3.0 SCHEME EVOLUTION

3.1 FEEDBACK FROM FIRST PRE APPLICATION

Following the first pre application meeting on 9 December 2019 the Council provided the following comments:

VIEW 9 FROM THE CONSERVATION AREA.

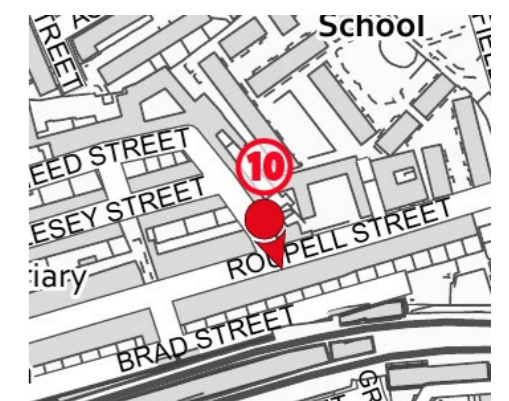
The officers noted that the views of the site from the adjacent Roupell Street Conservation Area were important considerations in formulating height. This was of particular note on the view of the site from Theed Street. Officers expressed the view that the proposed height should not breach the height of the chimneys in the key views.

In line with advice from LBL design officers the scheme was amended to reduce the height of the proposed building from 5, 9 and 13 storeys to a part 5, 8 and 10 storey building. The reduction in height allowed for the building to sit comfortably in views from Theed Street whilst not exceeding the heights of the chimneys.

Officers confirmed that this was an acceptable move and welcomed the reduction proposed within the current scheme. Officers also expressed support for the design which references the Art-Deco architecture of public housing in the inter-war years and the curvature of the brick detailing and banding.
